From: Laura Gibbons
Sent: 07 November 2018 09:26
To: Planning.Responses
Cc: Michael Eastham
Subject: RE: Planning Consultation on LU/281/18/DOC

Engineers Comments Regarding Condition 10- drainage

APPLICATION NO: LU/281/18/DOC

Site Address: Hampton Park (Parcels B3 & B5 - Plots 6 to 117 only)
Toddington Lane Littlehampton ME19 4UY

ROAD & SEWER SECTIONS

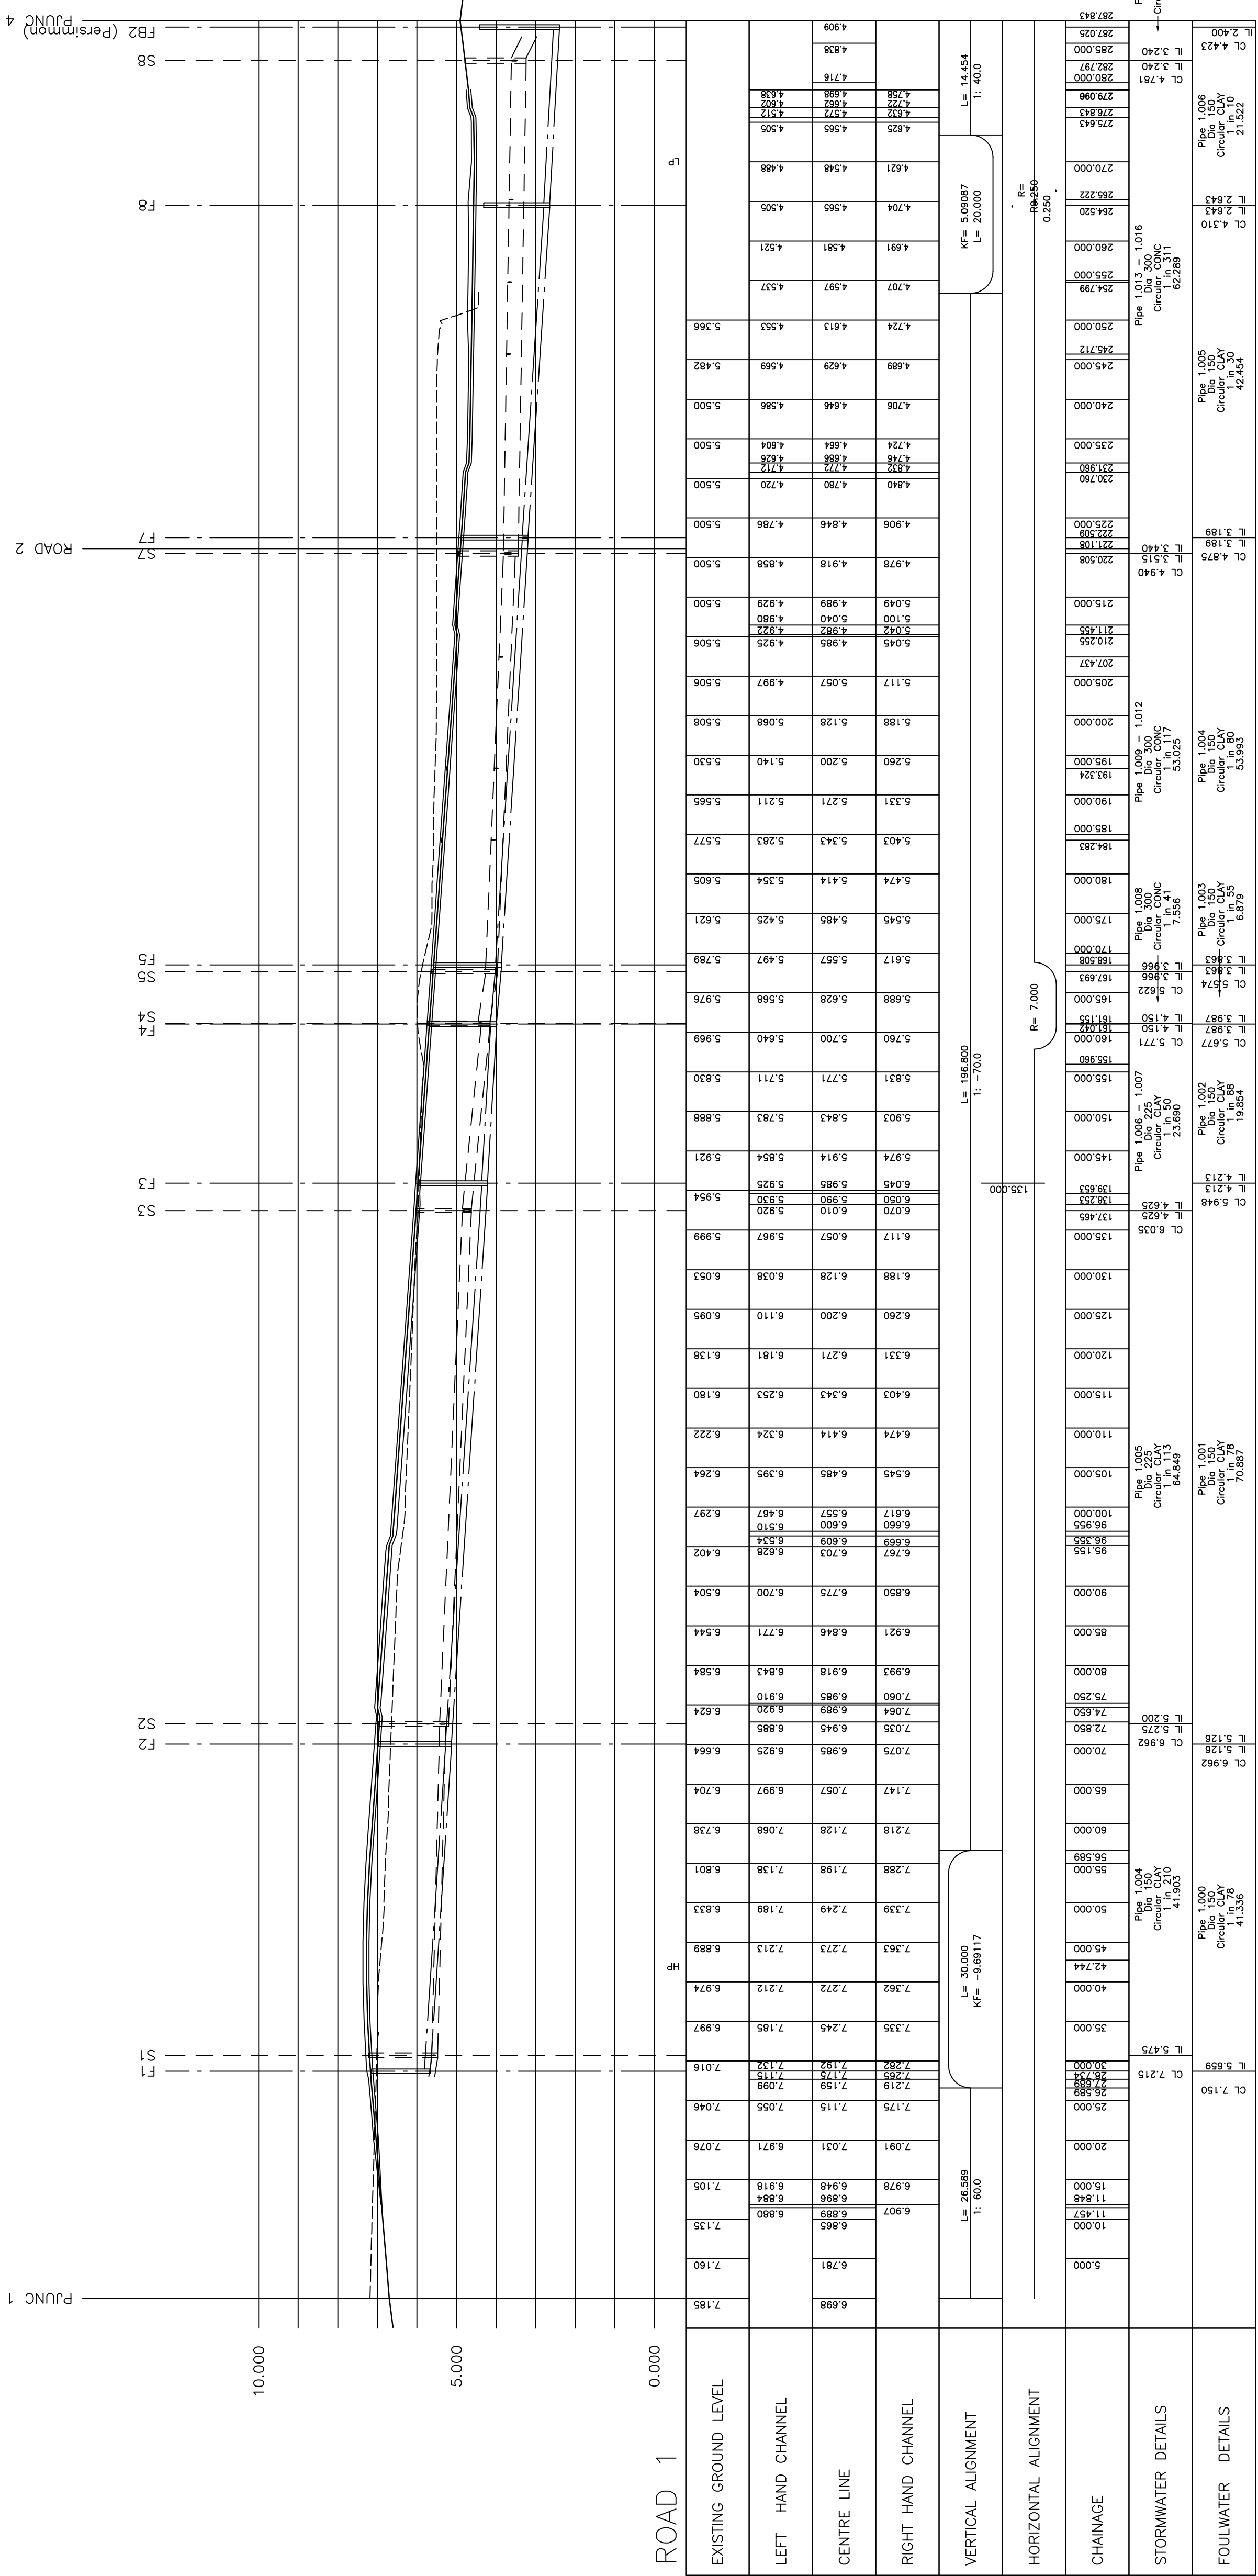
However, there are discrepancies between the invert levels on the manhole schedule and on the drawings.

It is also incredibly difficult to review the efficacy of the surface water drainage design as levels used in calculations do not relate to those on the plans and there is insufficient labelling of the plans to identify permeable paving areas represented in calculations and orifice manholes.
